Reviewed for Code Compliance

08/17/2022

30' x 40' x 12' H STORAGE BUILDING
(WITH 12' x 40' SIDE SHELTER (1/2 ENCLOSED))

30' x 40' x 12' H STORAGE BUILDING  
WITH 12' x 40' SIDE SHELTER (1/2 ENCLOSED)

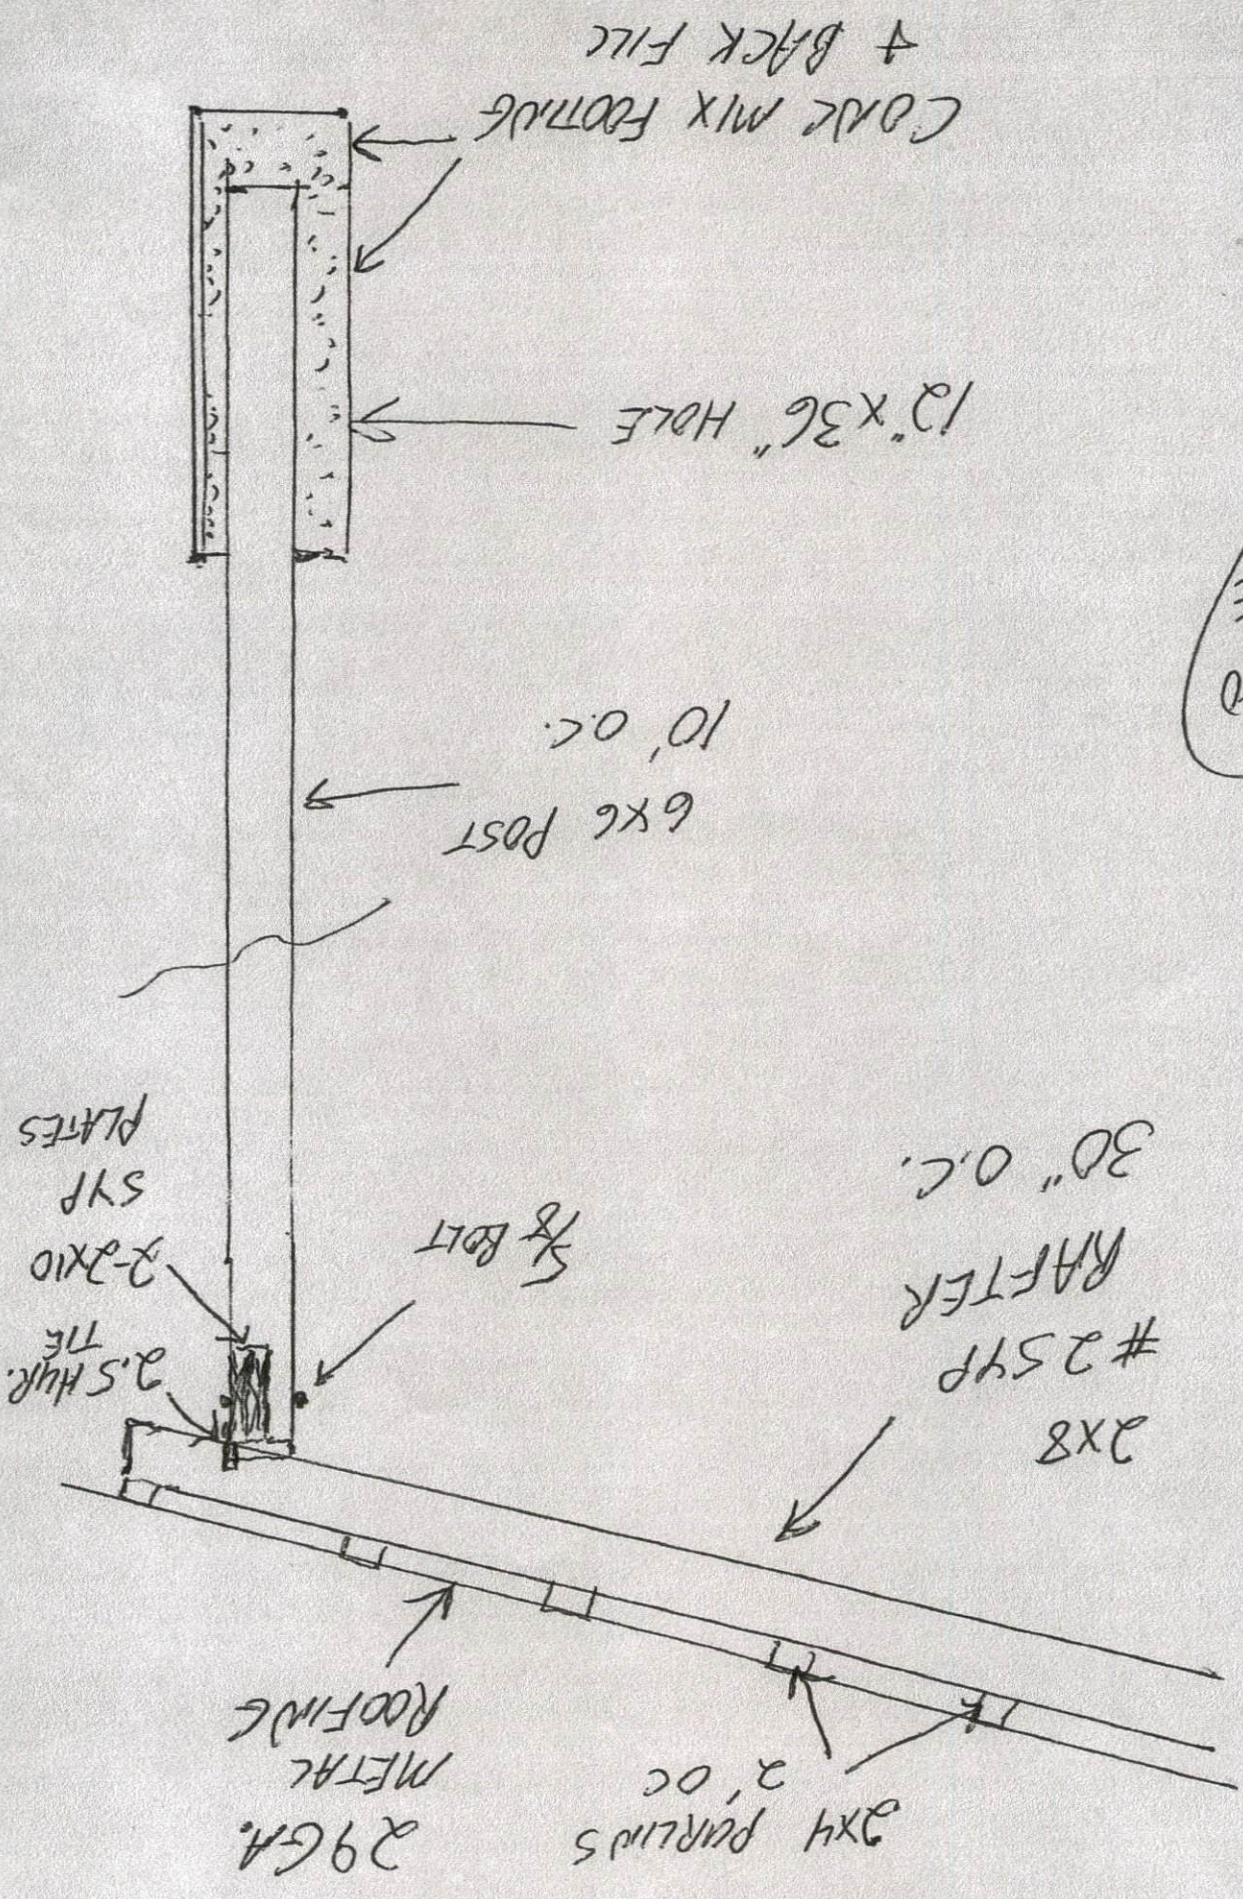
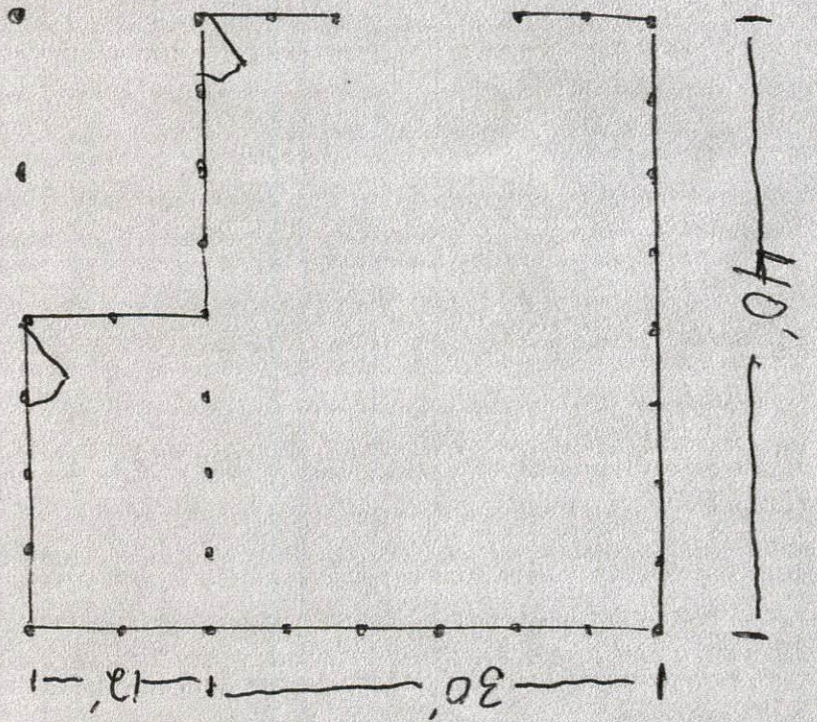
Building used for storage only. See notes on shelter plan

Max post spacing 8'

Max allowable spacing is 24" oc
